From: Town Clerk [REDACTED]
Sent: 26 July 2013 14:03
To: James Smith
[REDACTED]
Subject: McColl's Newsagent

Client	McColl's
Address	6242 Arundel
Project	New signage
Issue No.	07
Date	05-06-13
Scale	
Drawn	Chris Szramek
Approved / Date

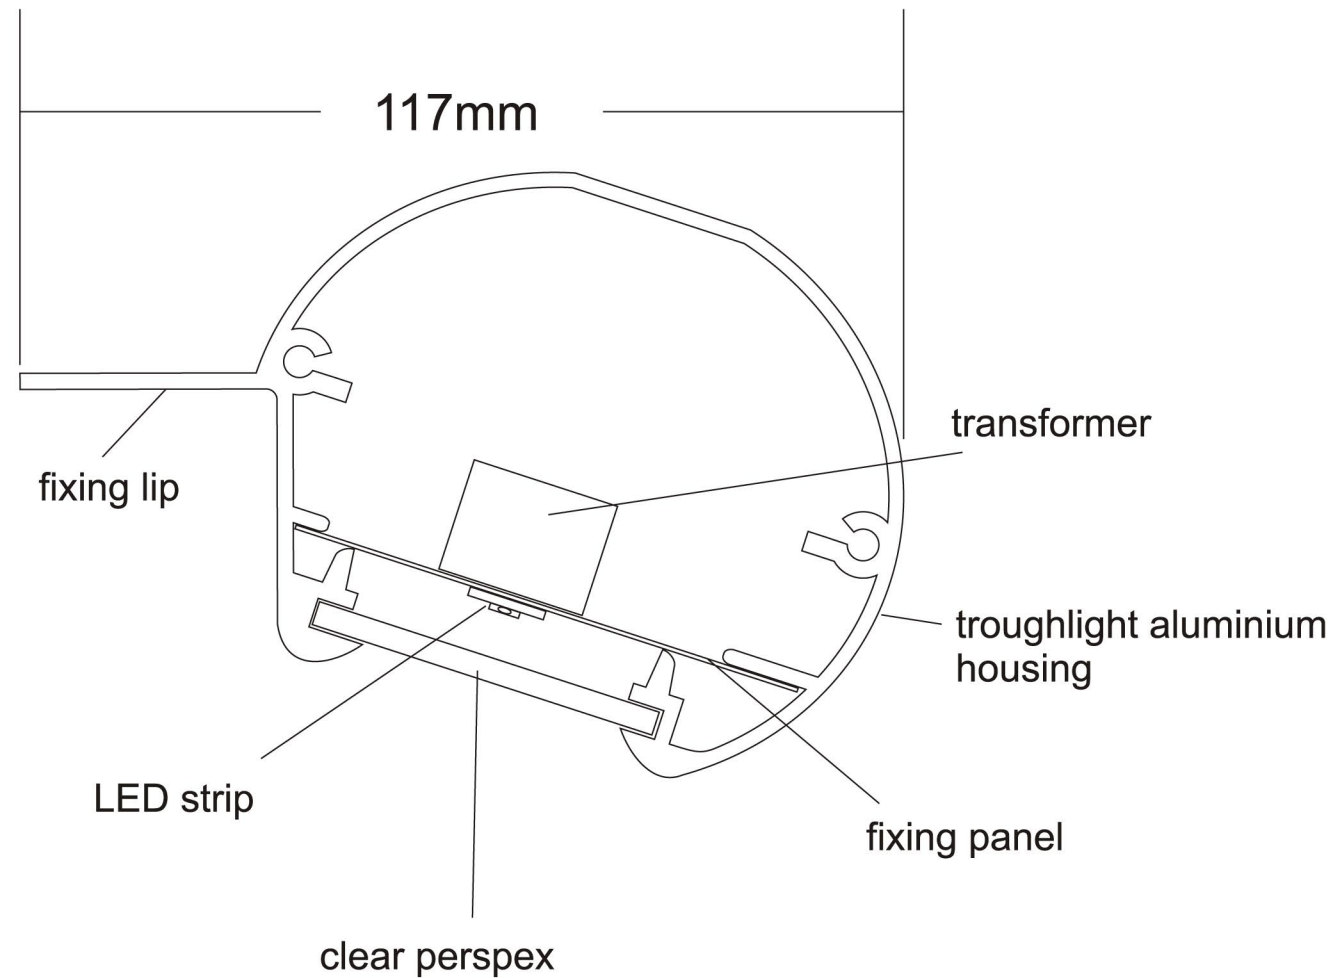
Further to our telephone conversation I can confirm our understanding that the lighting above the fascia name sign will not be allowed, however I can also confirm that Arundel Town Council have a serious objection to the fascia name sign as it is not in keeping with the listed building nor for the historic area that it is in, which requires a subtle and environment conscious approach to signage.
